### Department of Transportation

January 16, 2024

SH 24G / Stapleton  
El Paso County

RE: 4-Way Commercial Site Development Plan\_PPR-Plot Plan Review

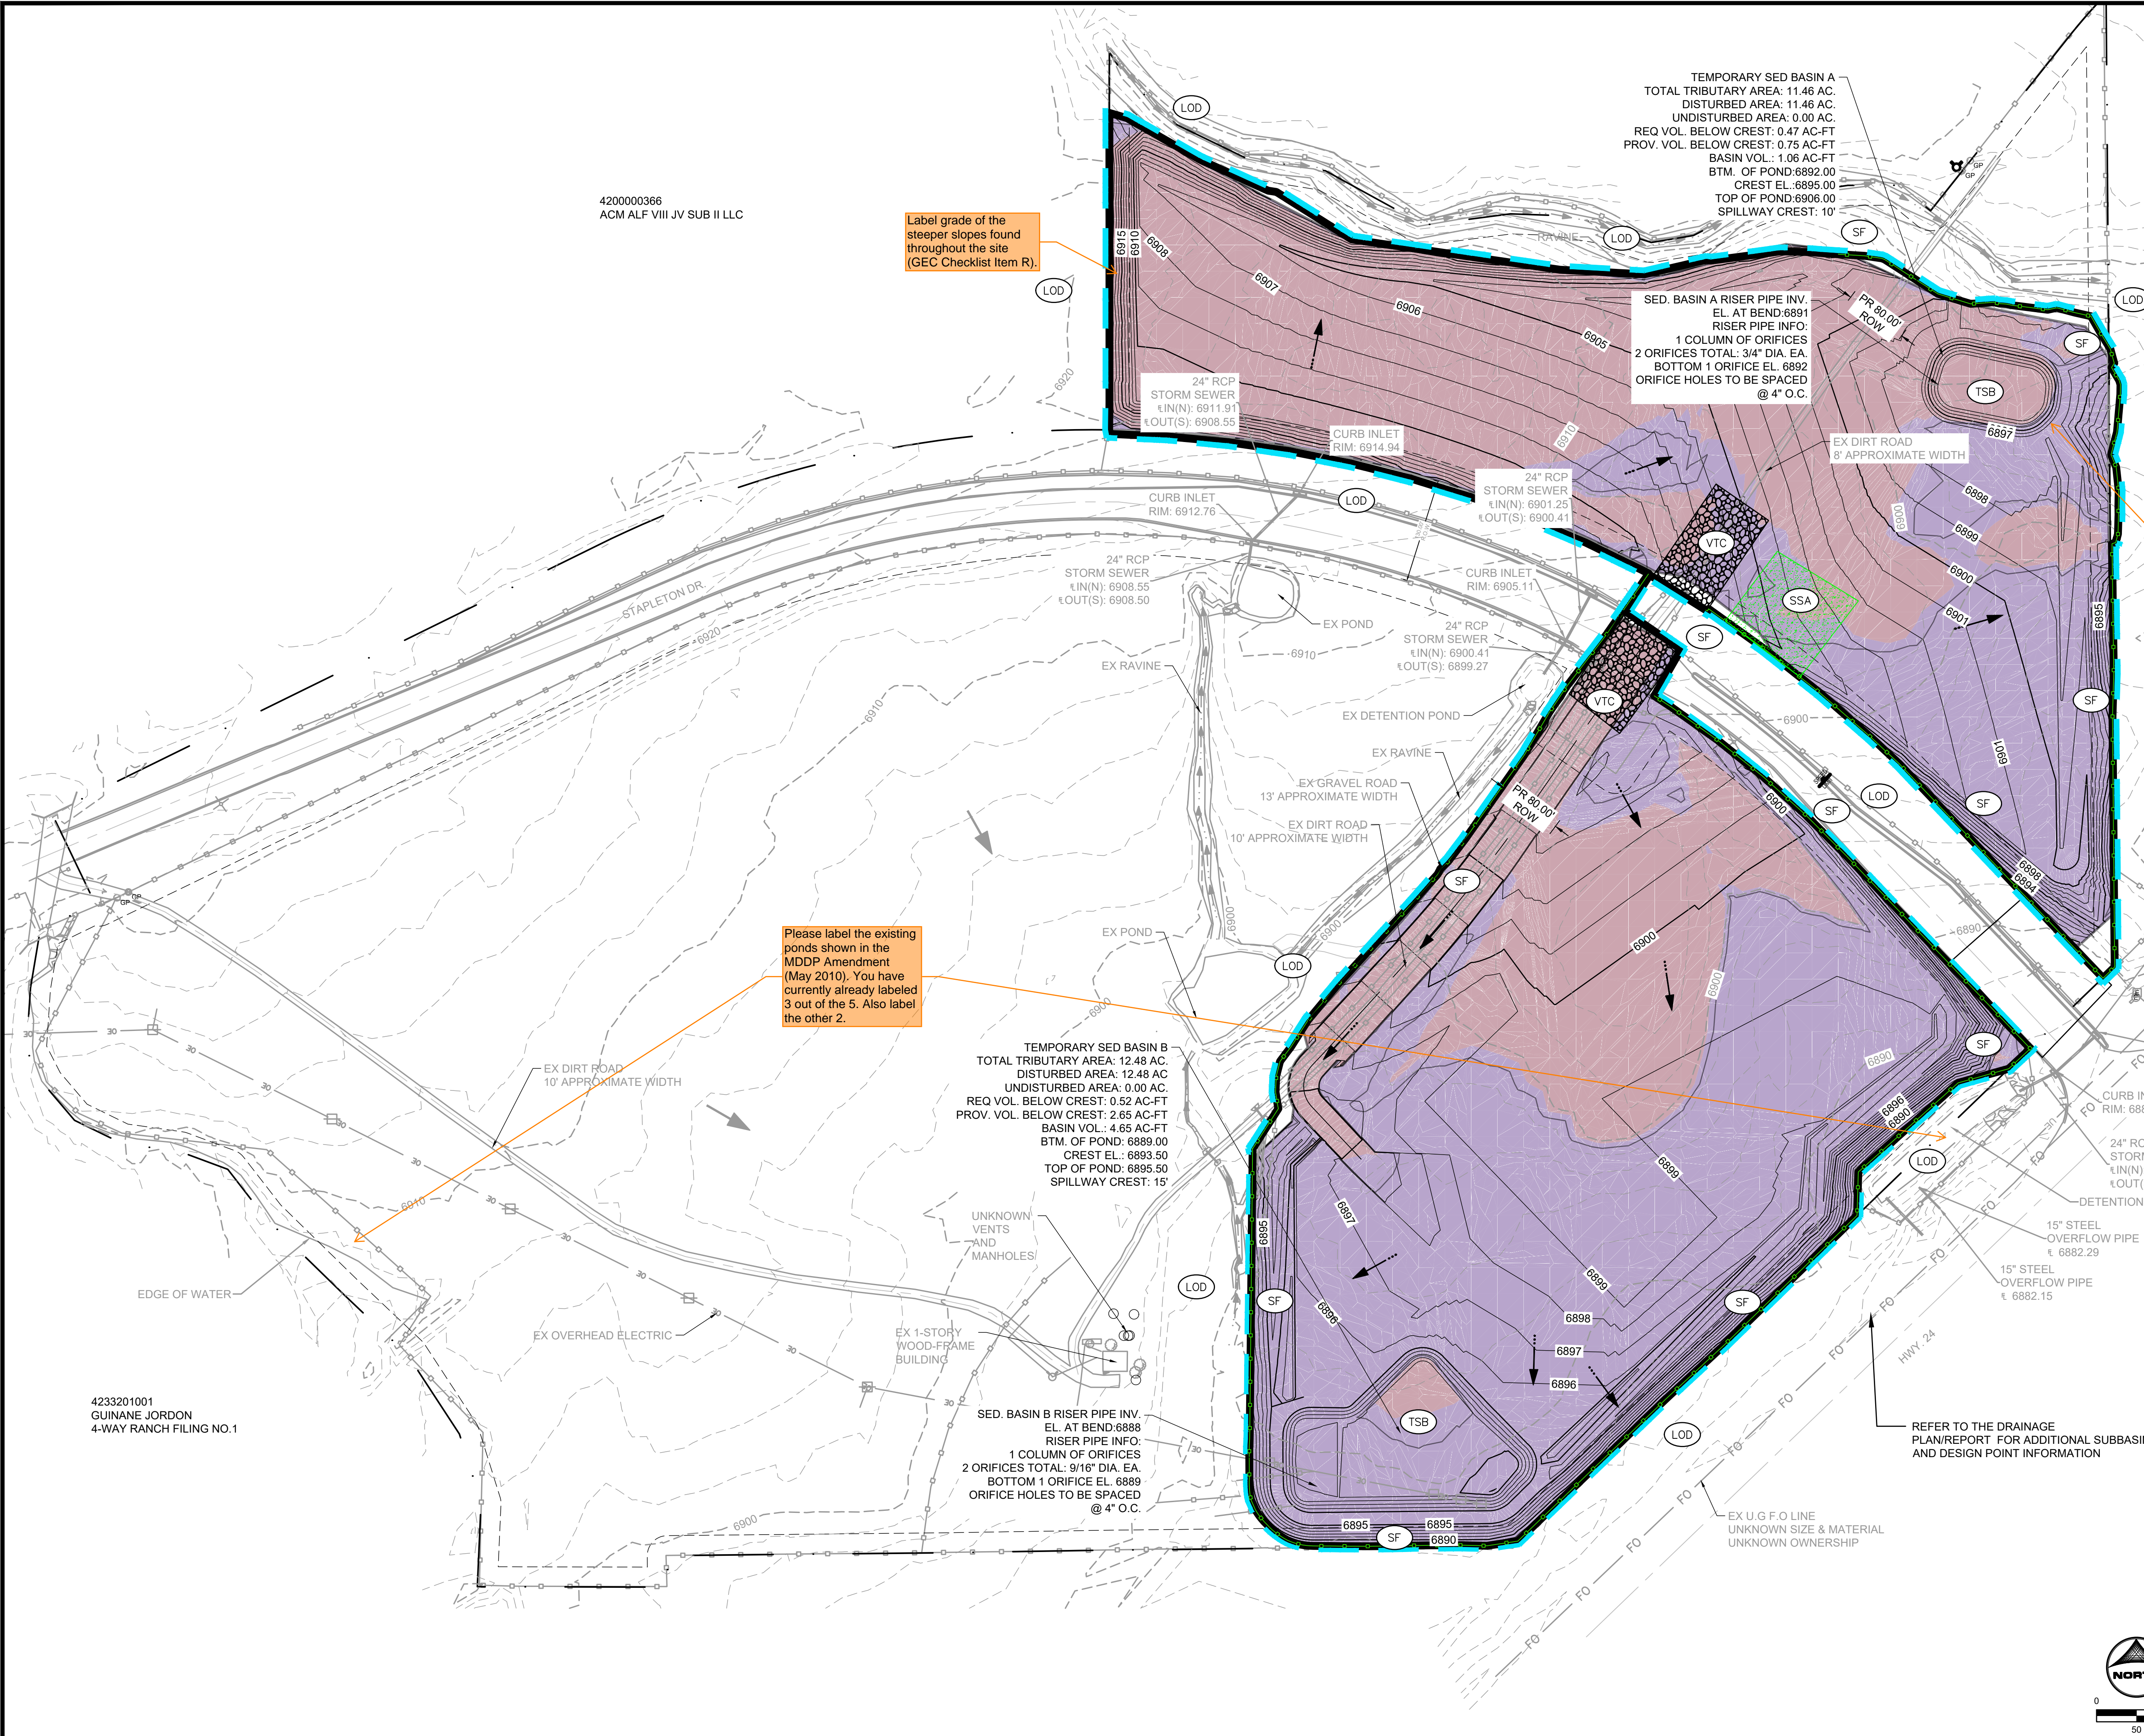
- SWMP Plan Comments:
- Sed Basin B lists the spillway crest as 15', however the drainage report indicates it is to be 33'. Have the impacts been analyzed for this condition? Please clarify.
- Report Comments:
- There are no detention calculations for Pond A. The SWMP Plan is not clear if both Pond A and B will be constructed during Fall 2024 construction. If so, please include the pond calculations to verify appropriate sizing.
  - Proposed grading plan - in the event the sed basins are overtopped, is capacity maintained in the ditches adjacent to CDOT ROW? Please clarify.
